OBJECTION

The APC has no objection in principle but is asking for more information. It is understood that the embankment and culvert would form part of the Angmering Flood Risk Alleviation Scheme and that in the event of flooding flow would be restricted through the culvert and a holding lake/pond formed against and upstream of the embankment. This is necessary to prevent an excess volume of water overwhelming the culvert at Weavers Hill in extreme flood conditions.

**WATER LANE, ANGMERING
BOX CULVERT
EXISTING
PLAN, SECTIONS & LEVELS**

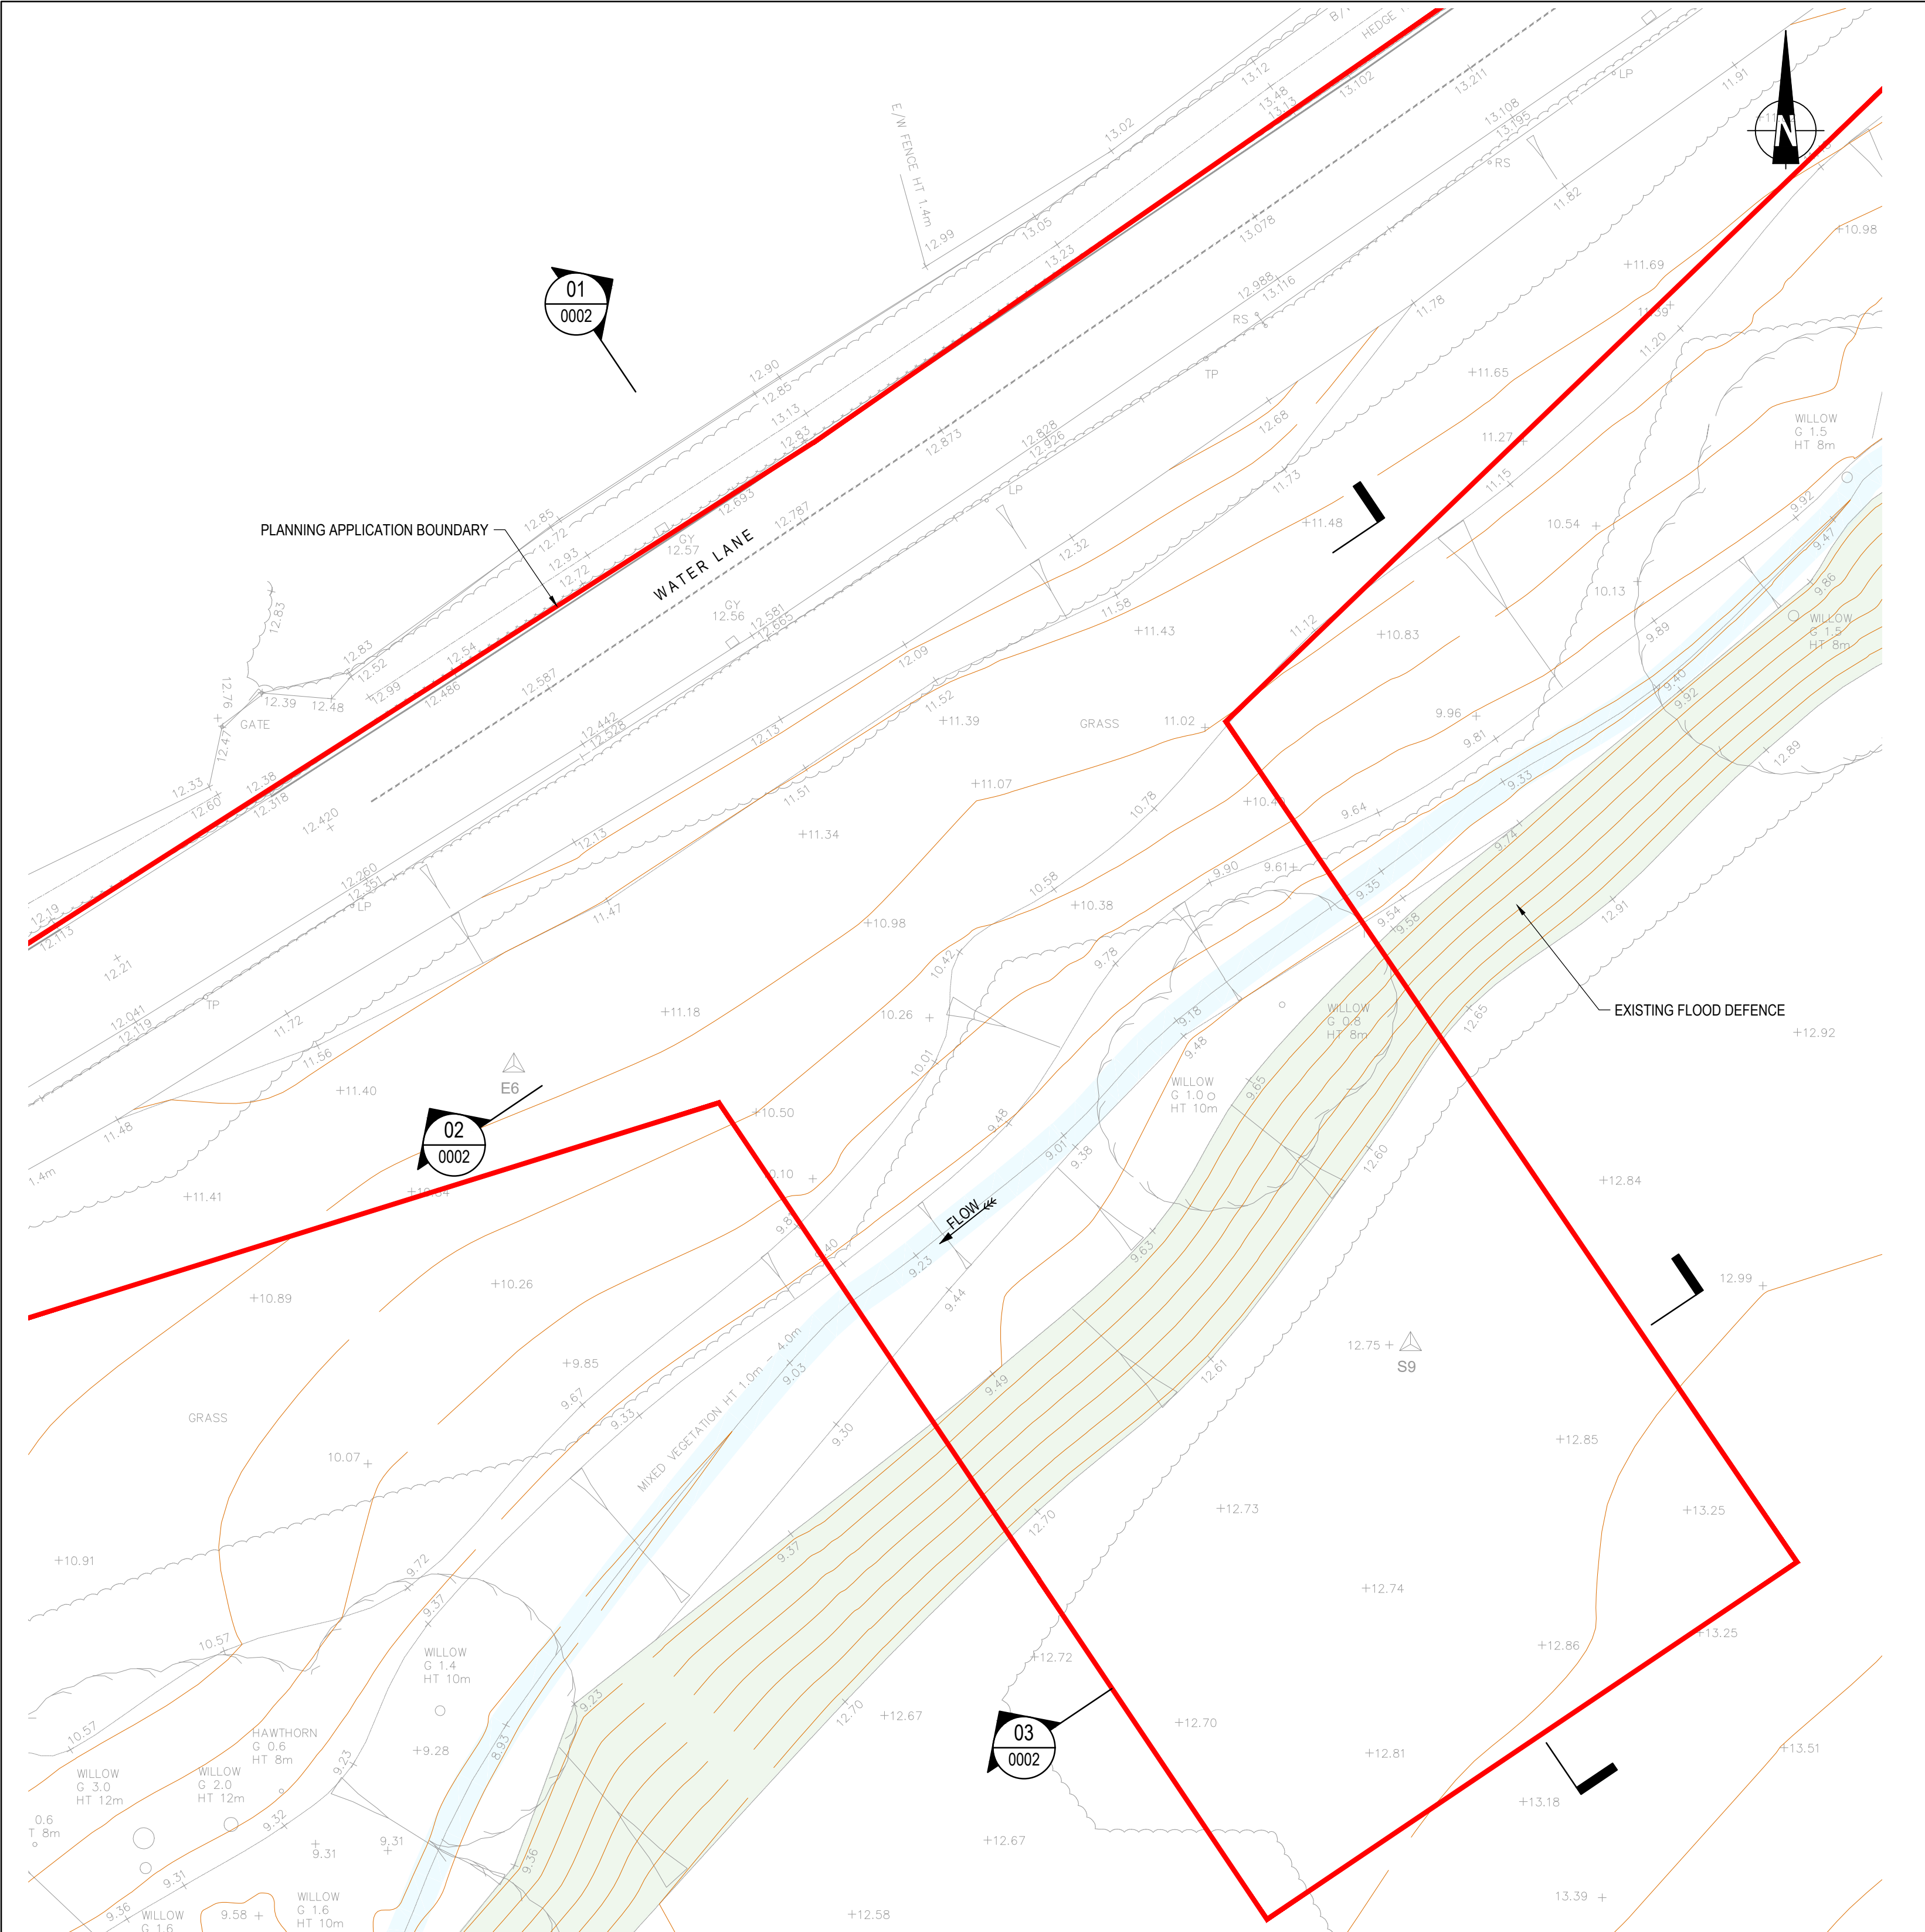
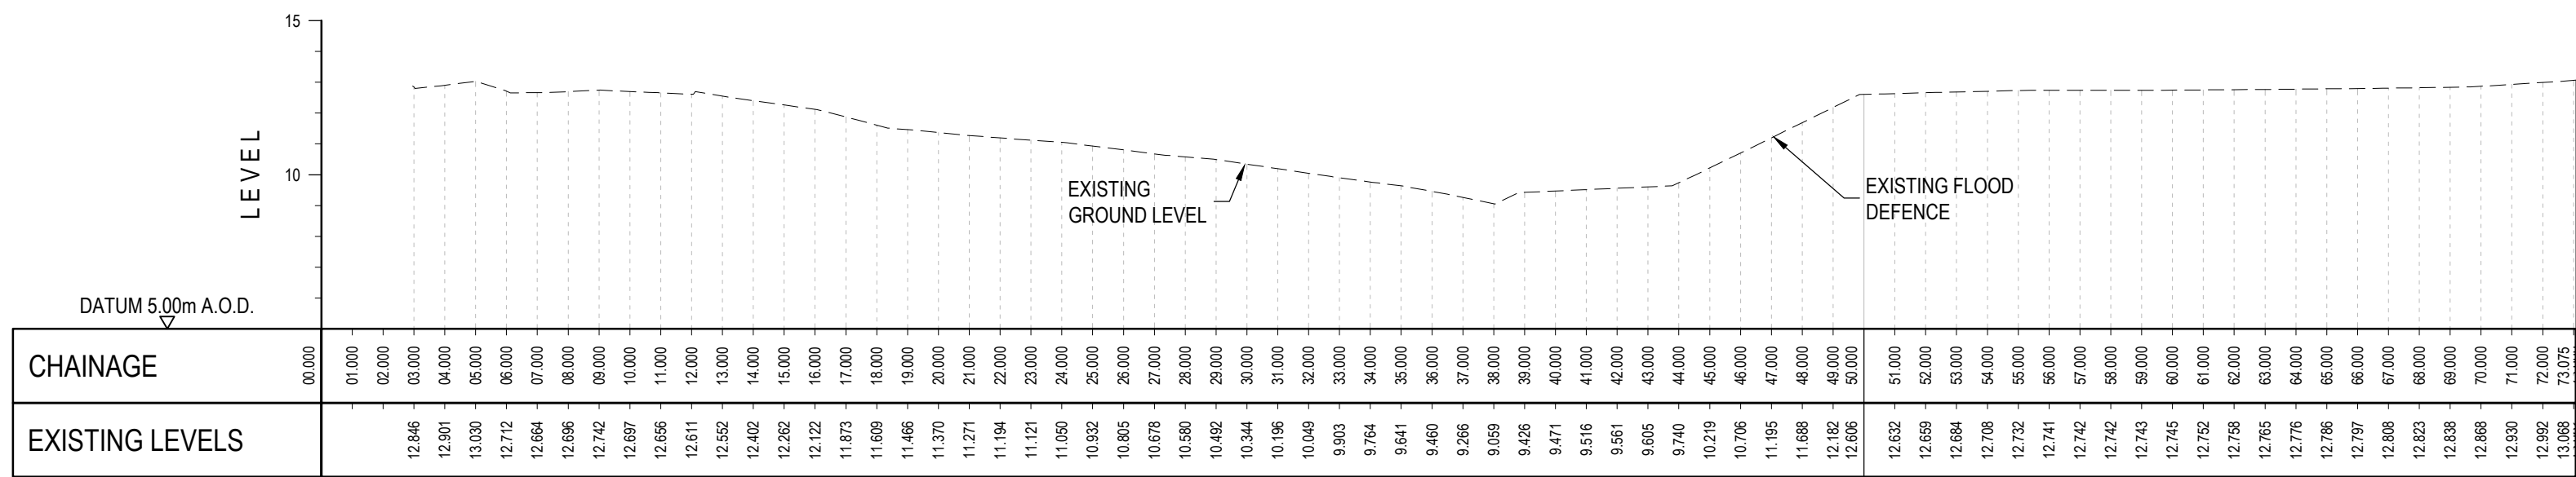
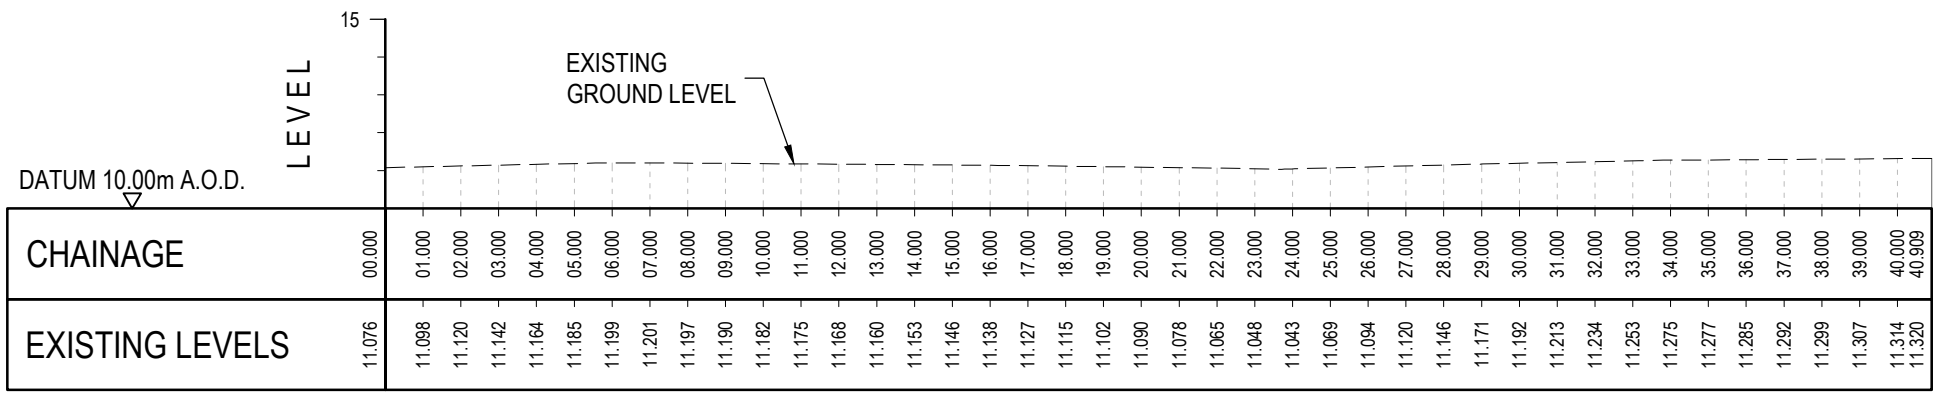
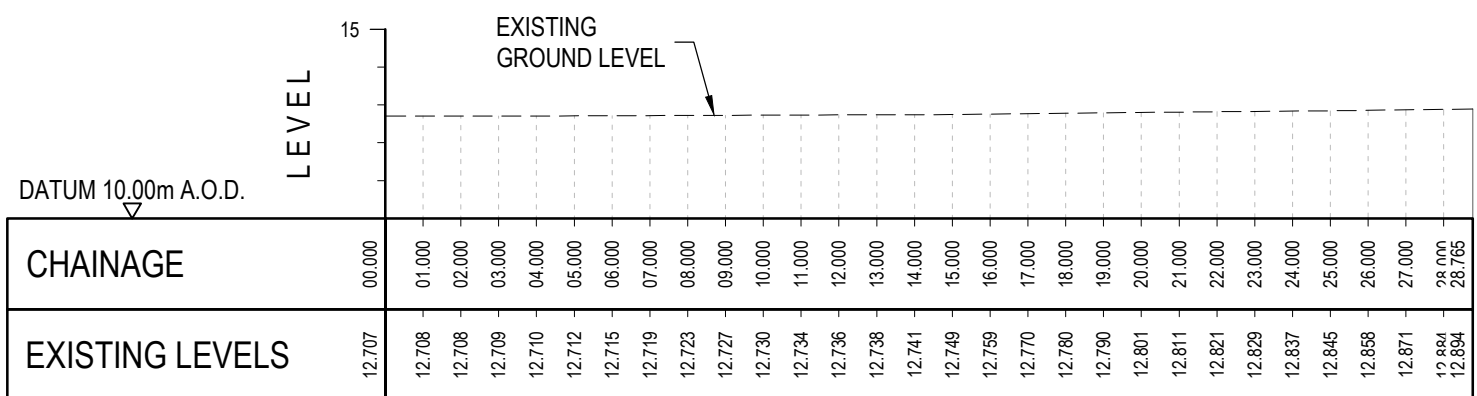
Before giving our approval we would wish to see details showing the positioning of the “throttling” at the culvert and have a plan of the lake that would be formed in flood conditions, showing its extent with an indication of its maximum depth. From plans submitted the latter would appear to be approximately 2 metres; can this be confirmed?
